MMO Reference: DCO/2021/00002  
Planning Inspectorate Reference: EN010119  
Identification Number: 20051047

25 April 2025

**Planning Act 2008, Proposed North Falls Offshore Wind Farm Project Order  
Deadline 4 Submission Summary**

Plate 1.2 Proposed piling mitigation procedures.

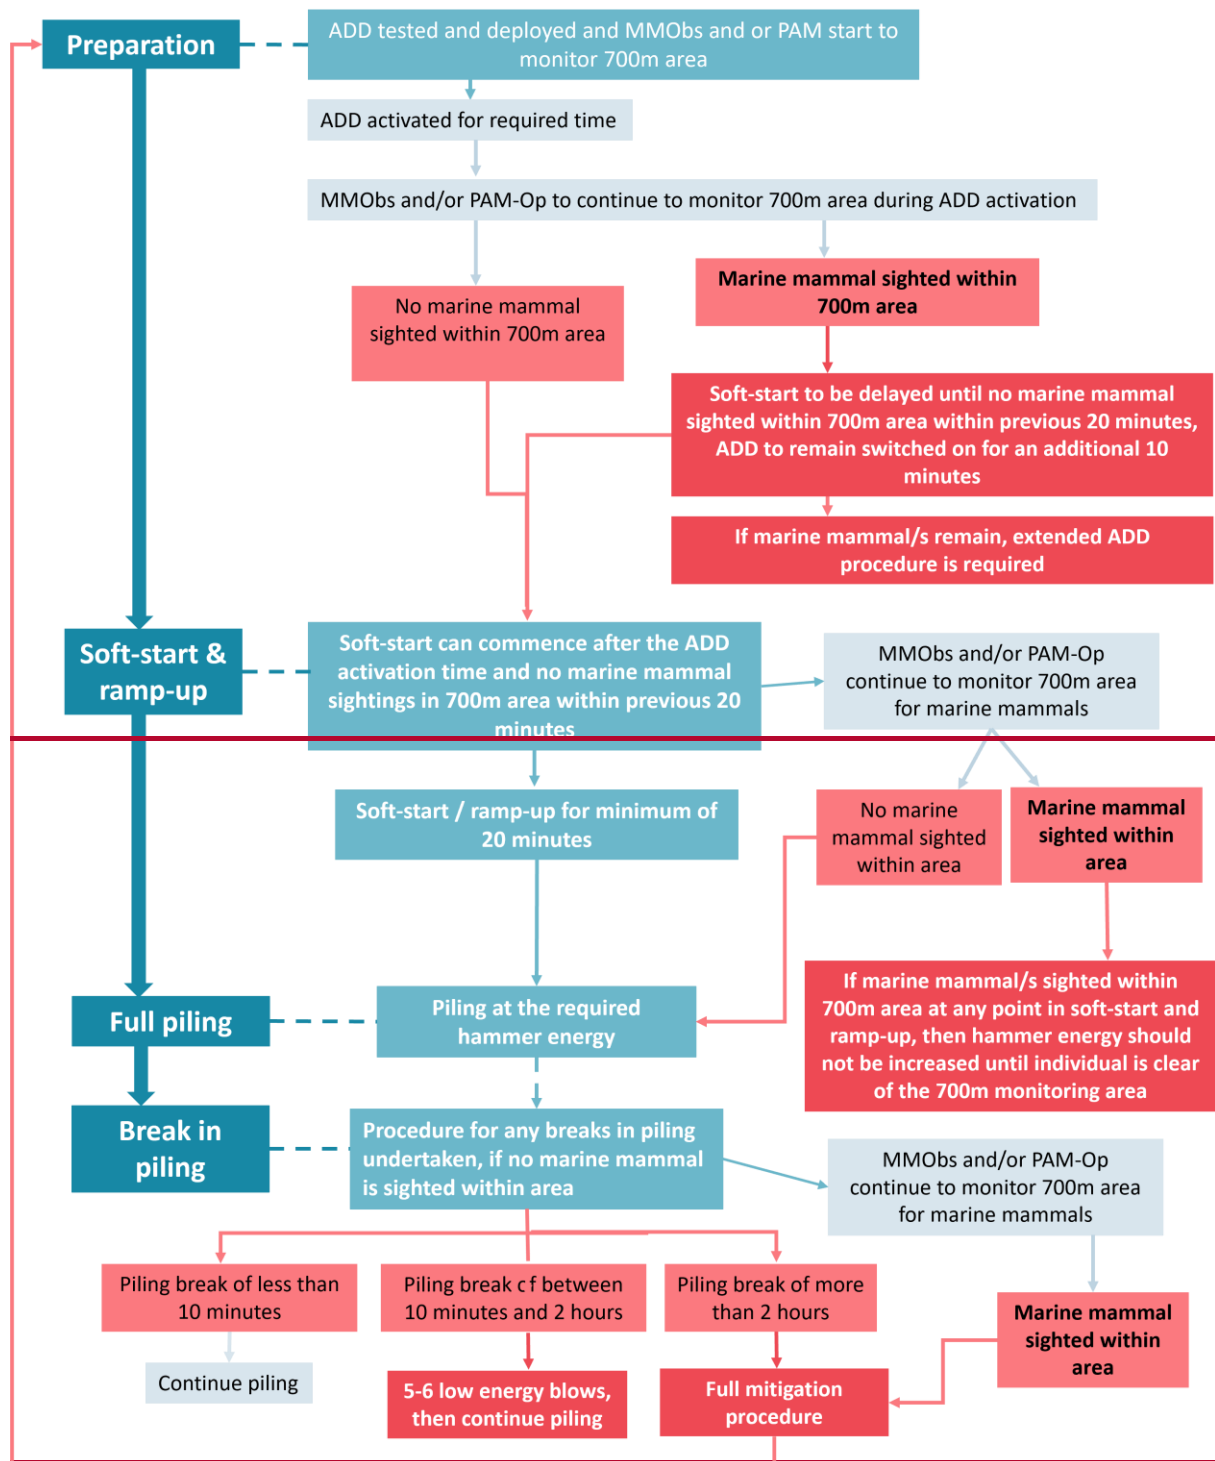
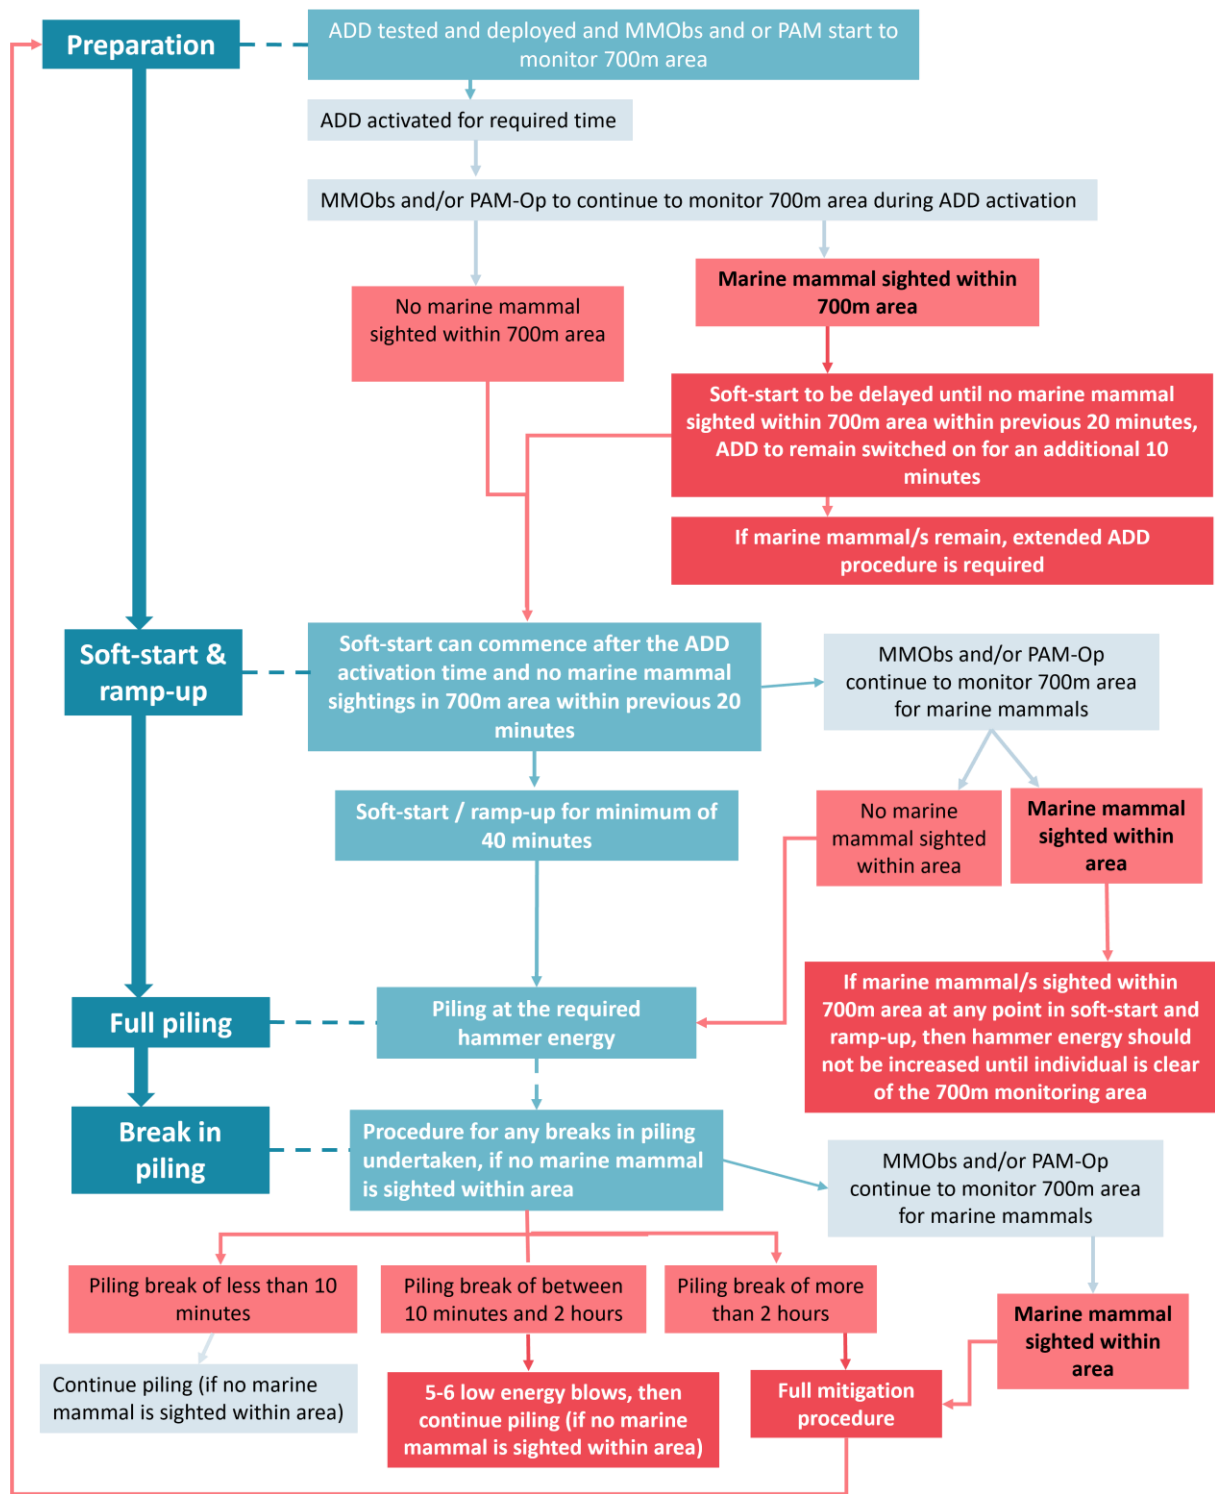
- 4.2.10 The MMO welcomes the clarification in Section 1.3.2.4 that continuous monitoring will be ensured throughout piling, including any break in piling, to ensure the monitoring area is free from marine mammals before piling recommences.

- 4.2.11 The MMO notes that the Applicant considers the requirement for another full soft start period to be disproportionate, instead of the 5-6 hammer blows at low energy (<400kJ) which the Applicant considers will allow any marine mammals that may have moved nearby during the break time to move away again without providing any excessive noise. The MMO maintains their position that the guidance is adhered to and the full soft start is implemented and this should be reflected within the MMMP. The MMO is open to further discussion on this requirement post consent once the final design is confirmed however at this time the guidance should be adhered to.

Appendix B. Plots for Comparable Hammer Strike Energies

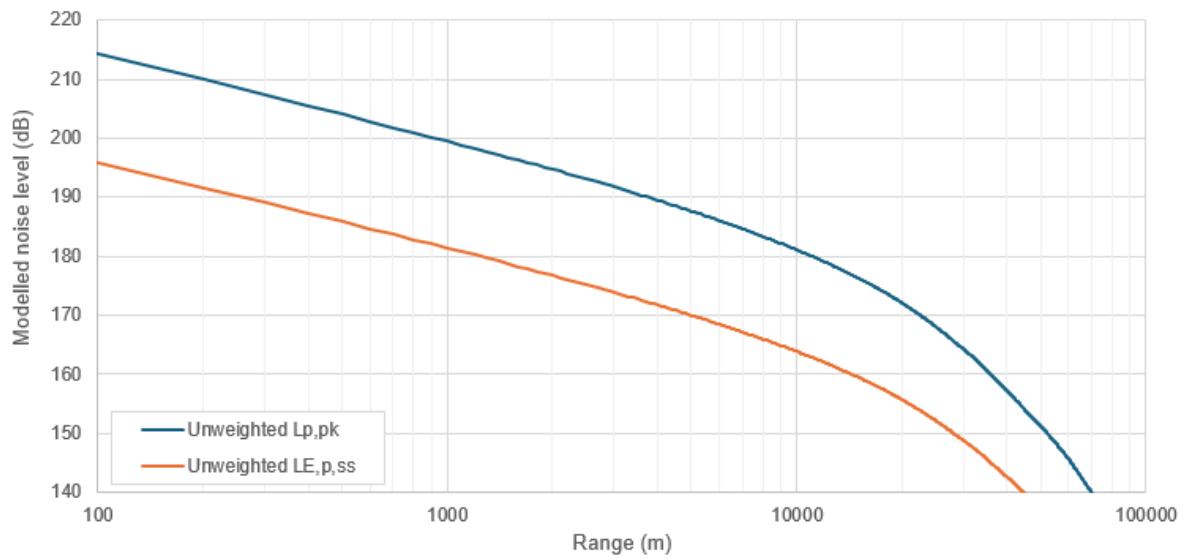
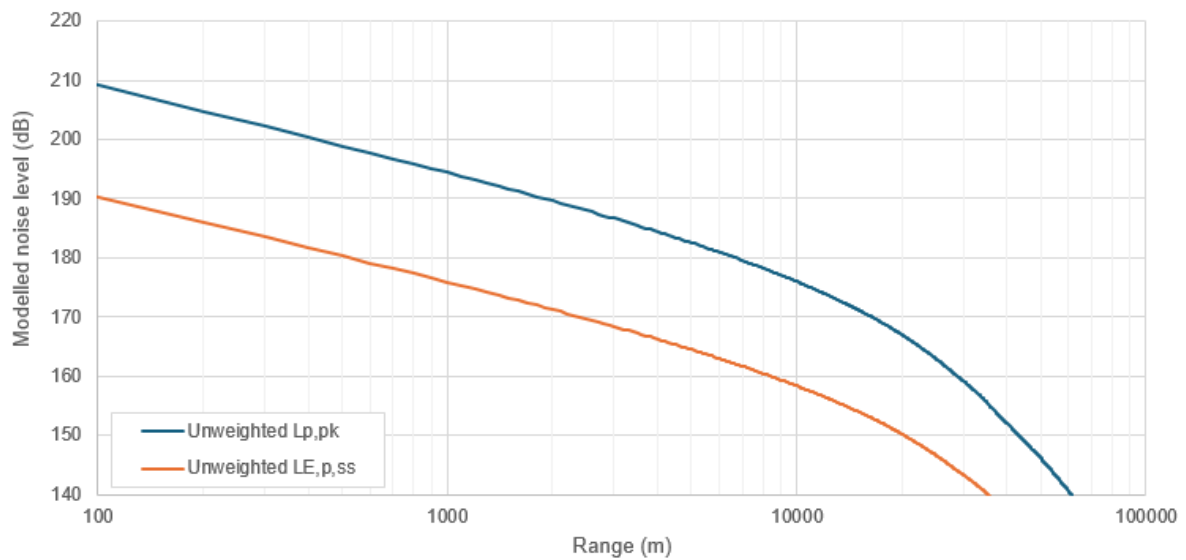
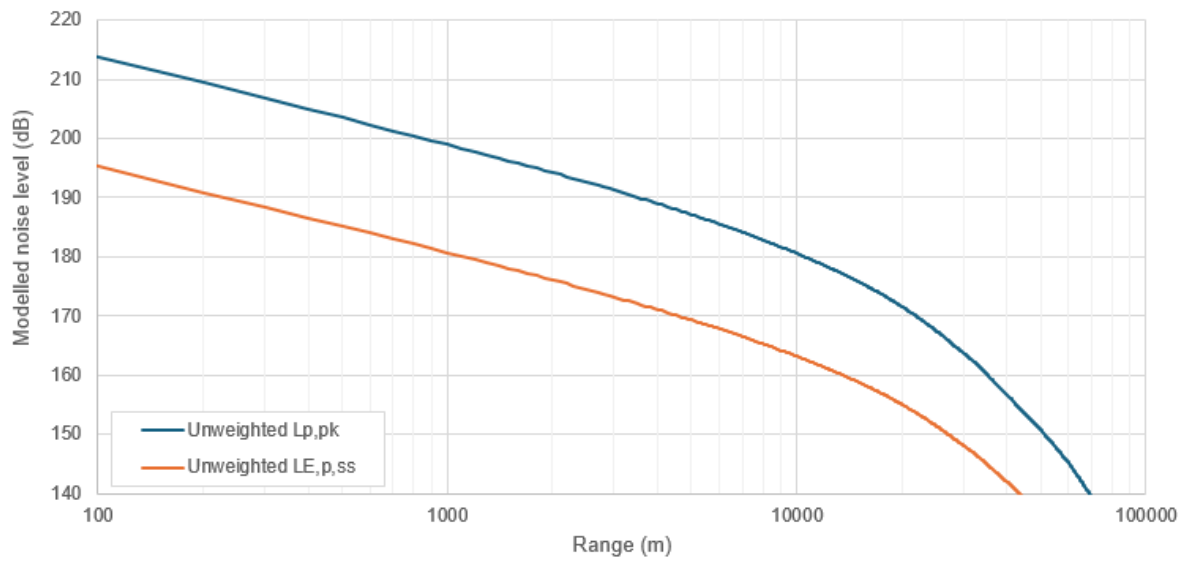
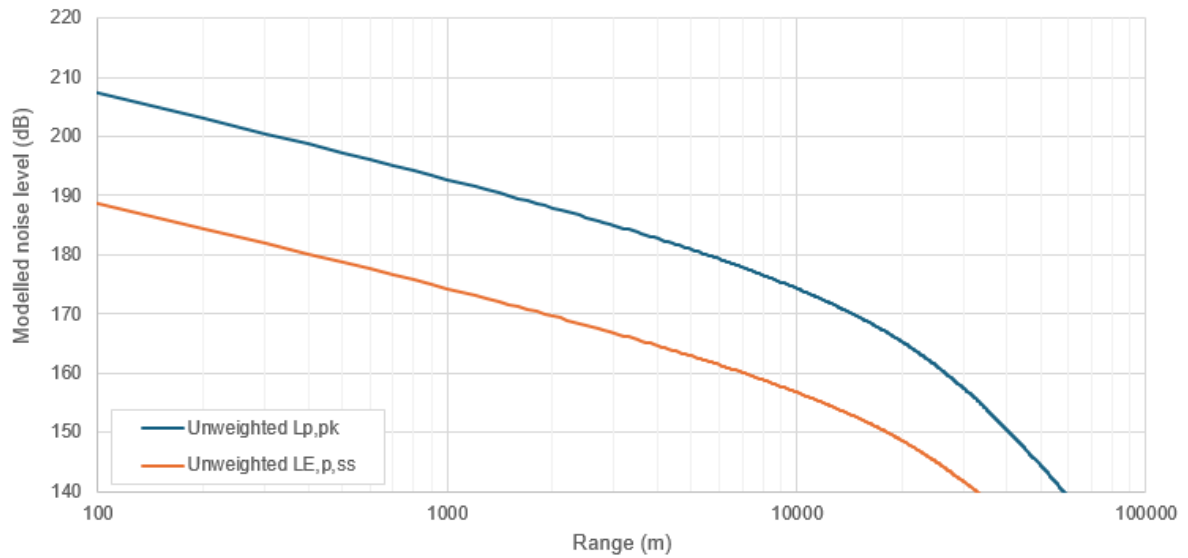
- 4.2.12 The MMO welcomes the clarification in Paragraph 108 to ensure that if high-order clearance is required then NAS must be used.
- 4.2.13 The MMO recommended in their comment MMO-195 that the level vs range plots (for comparable hammer strike energies), with the associated envelopes of variability are provided. The MMO welcomes that these plots have been provided in Appendix B as part of the revised Draft MMMP and is currently reviewing these with our scientific advisors and will confirm this matter is closed at Deadline 5.
